Foxground and Berry Bypass (MP10_0240) – Environmental Assessment

I make the following submission as an individual resident though it's based, in part, on my experience of serving on the Community Review Group from August to December 2012 and on a working group which was particularly concerned with the South-Western Interchange - which the RTA/RMS (hereafter referred to as 'RMS') calls the Kangaroo Valley Interchange. My submission calls this 'S-W Interchange'.

Figure 4-3 Section 3 (Northern interchange for Berry to Mullers Lane)

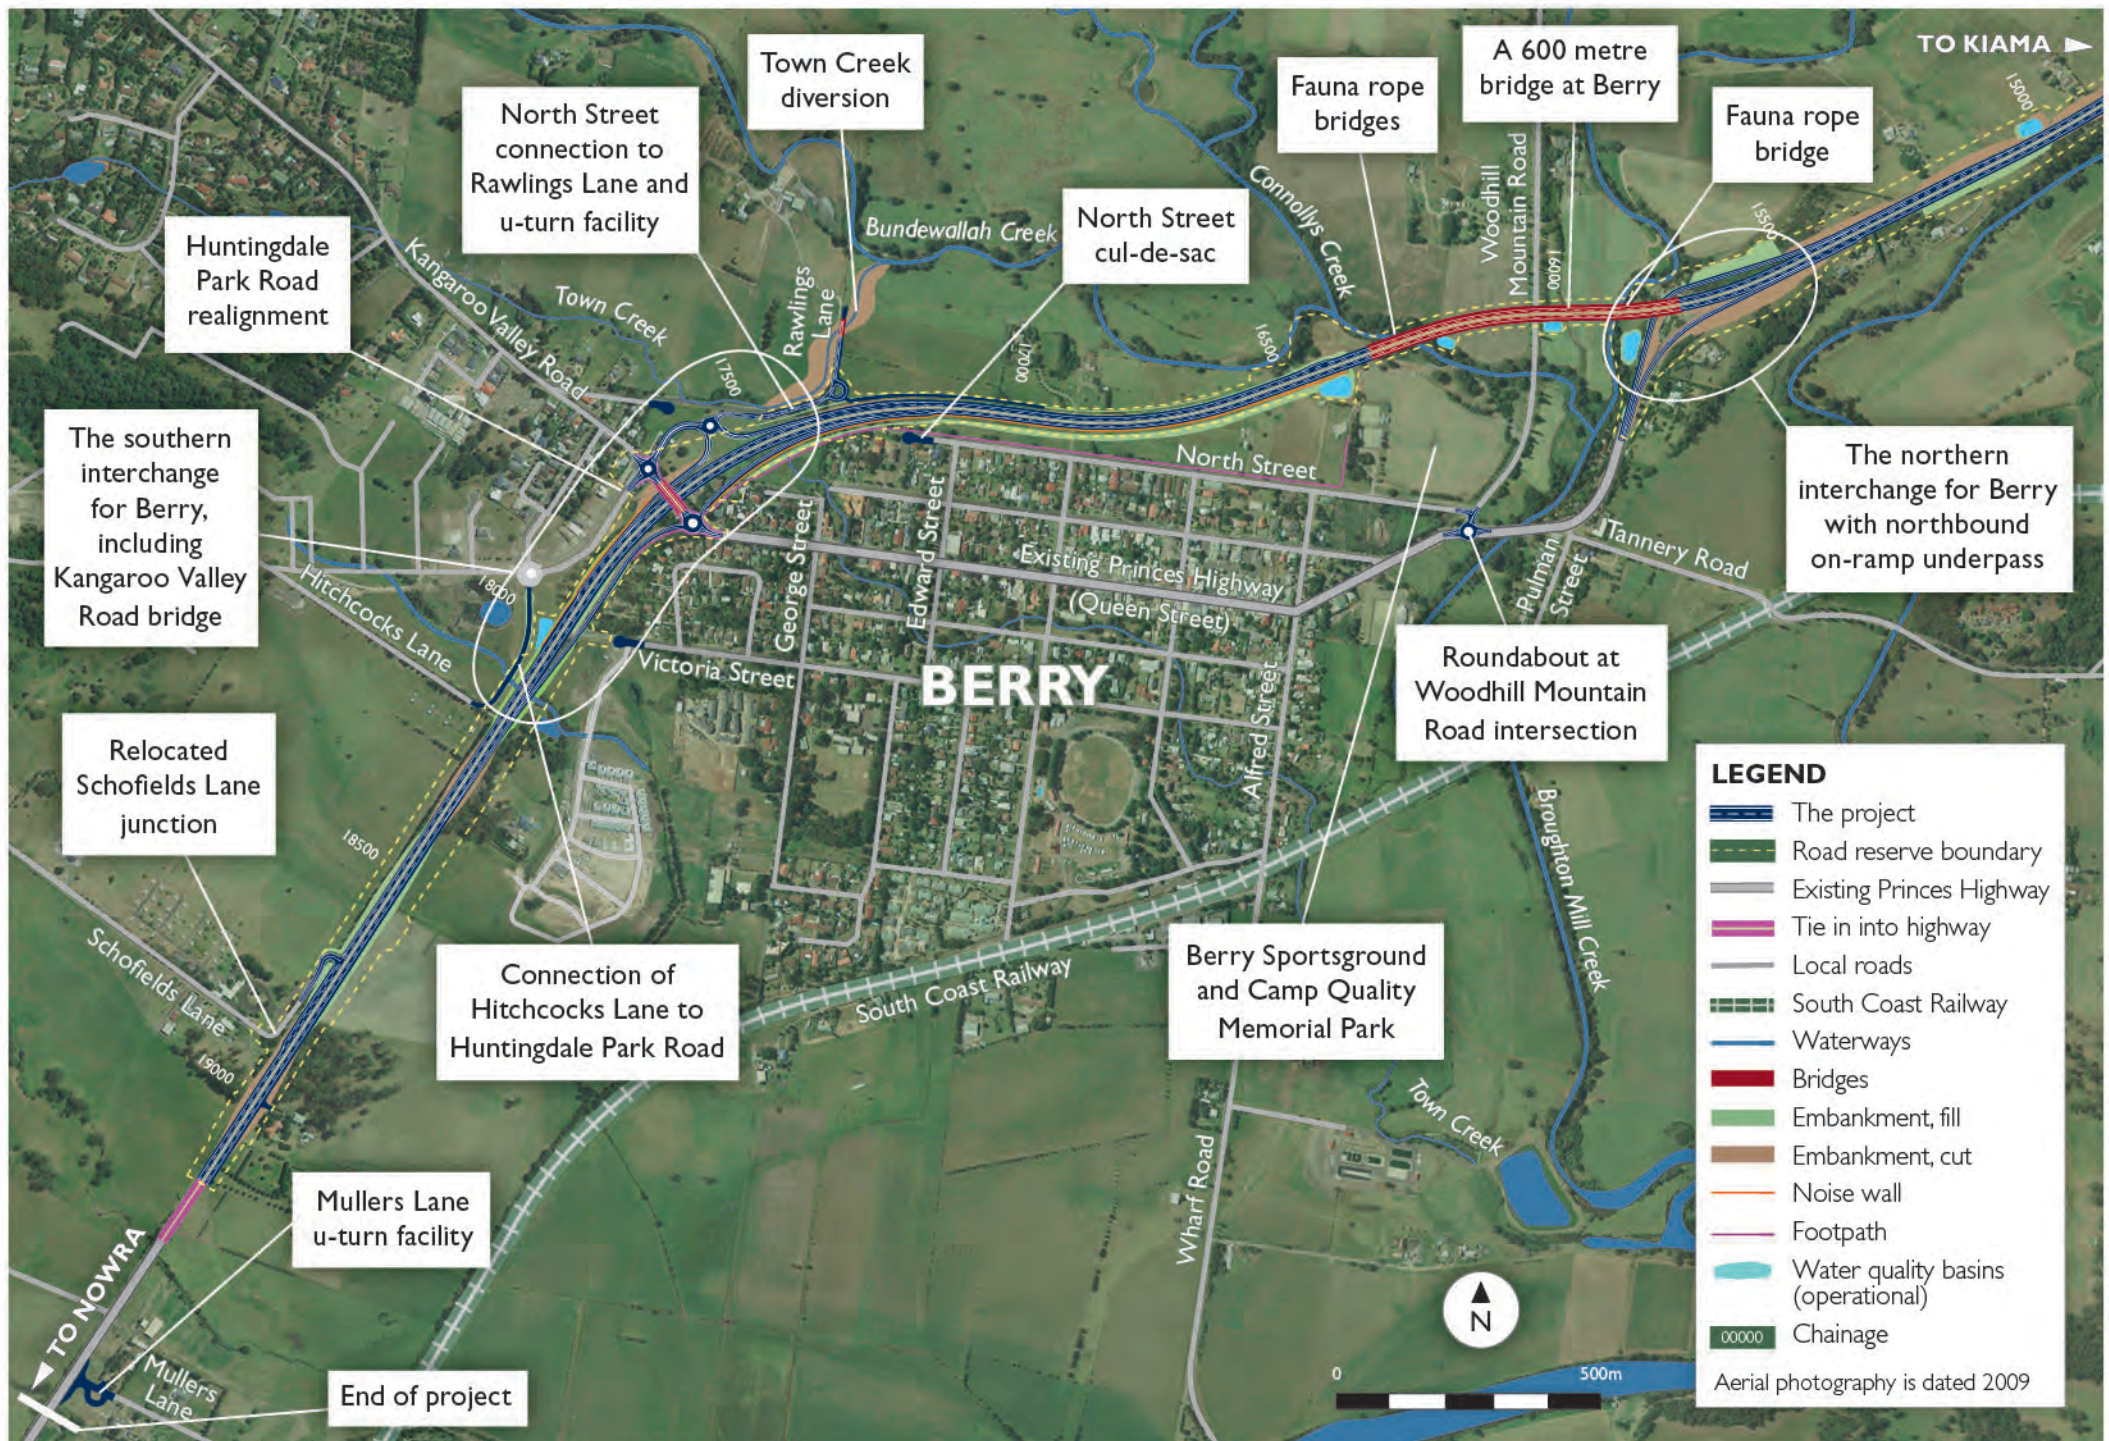
On closure of Victoria Street at Mark Radium Park, you will have received many submissions opposing it. I've described the abuse of process which led to its consideration.

At the June public forum, it was agreed that Victoria Street was properly a local traffic management issue. SCC argued for Model 3 - 'left in, left out and right out' - an option as close as possible to the status quo.

Model 1 would triple traffic through the cross streets - refer AECOM's Summary of Traffic Impacts. RMS describes the Victoria St/Princess Hwy junction as one of the 'conflict points' and goes on to describe benefits of Model 1 as "'acceptable changes to local roads - increase traffic on George and Edward'. In an e-mail to RMS I wrote: 'These are intersections - something we encounter on every car journey we make' and then asked; 'Just how does increasing traffic threefold on narrow residential streets 'improve road safety'?' RMS did not reply.

The Berry-based Police Senior Constable has told us that there are no records of collisions there. If that's the case now, when the Highway carries through traffic, the junction will surely be even safer post-bypass?

Much of the RMS rationale for closure has to do with Mark Radium Park. Their 23 May 2012 Notes describe Model 1 as having marginally less impact on the Park than either of the other two. Progressively, under questioning from residents, that differential has disappeared, to the point that RMS has now conceded there's almost no benefit to the Park from Victoria Street closure.

Figure 4-12 Bird's eye view and cross section of the Kangaroo Valley Road bridge at the southern interchange

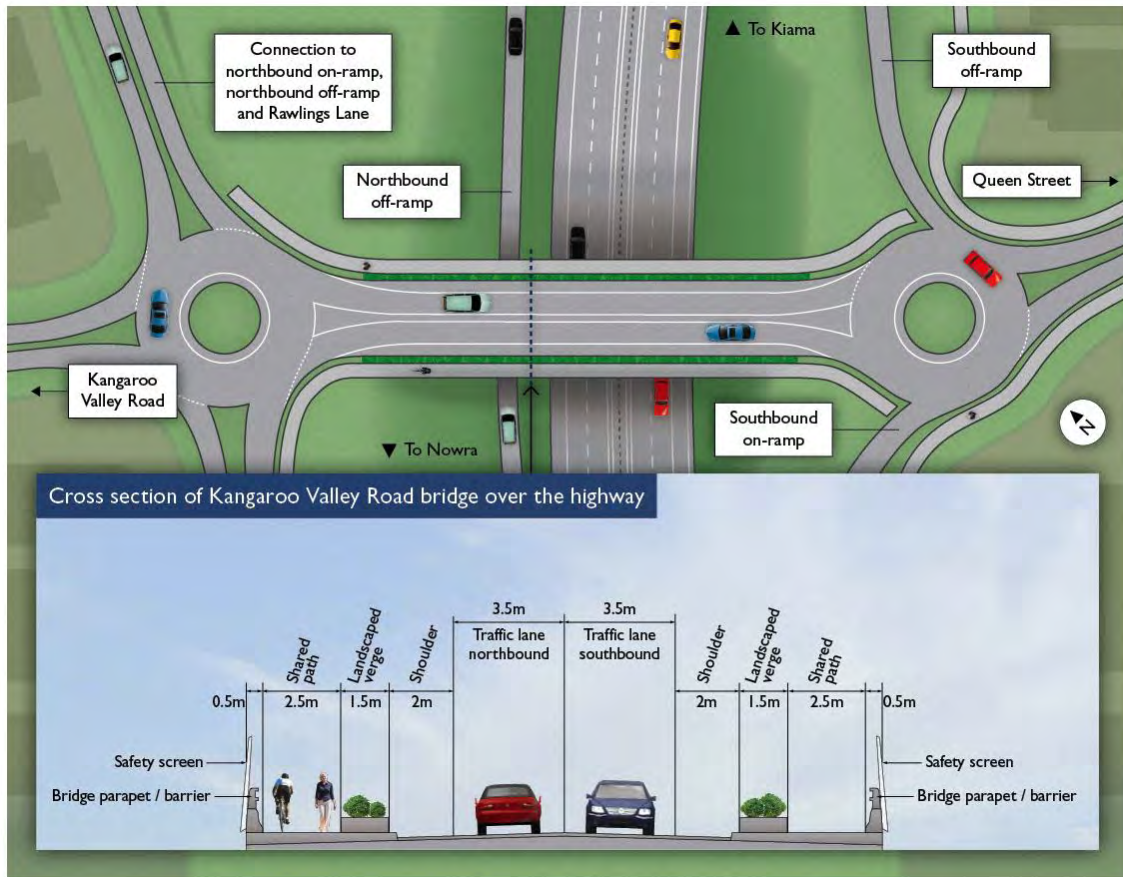
The bisecting of the town means that the half of the population which lives in West Berry will be separated from schools, churches, shops and sporting facilities. The RMS proposal exacerbates that lack of connectivity by a long bridge and two large roundabouts on Kangaroo Valley Road (KVR). It also doesn't sufficiently address pedestrian and cycle safety issues.

Alternatives which addressed each of these concerns have been proposed, only to be summarily dismissed on the basis of cost. Two others residents and I presented RMS with a S-W Interchange split ramp option which would:

- relocate the Southbound on-ramp and Northbound off-ramp to Schofields Lane/Graham Park
- remove two large roundabouts on Kangaroo Valley Road
- replace the bridge on Kangaroo Valley Road with a pair of Bebo arches (cut and cover)

In response to a suggestion in April 2012 that Bebo arch (cut and cover tunnelling) for KVR would be less obtrusive and quieter, Adam Berry wrote " would be in the order of three to five times more expensive" I replied "After 9 months of the current review process, we're long past the point where RMS simply answers detailed questions with statements like 'three to five times more expensive' It may well be the case, but I'd still ask for specific answers to questions about depth, soil type etc. Those roundabout footprints are one of the concerns expressed by people who live near their location and/or would have to traverse them." RMS didn't reply

RMS also argued that the split S-W interchange would increase the footprint. Counter argument that the net effect, which would include removing those intrusive roundabouts at KVR and retaining the Berry gateway with Mark Radium Park would neutralise any increased footprint were ignored.

It does not justify excising this option and, given my comments about process, I would ask that this option be properly examined
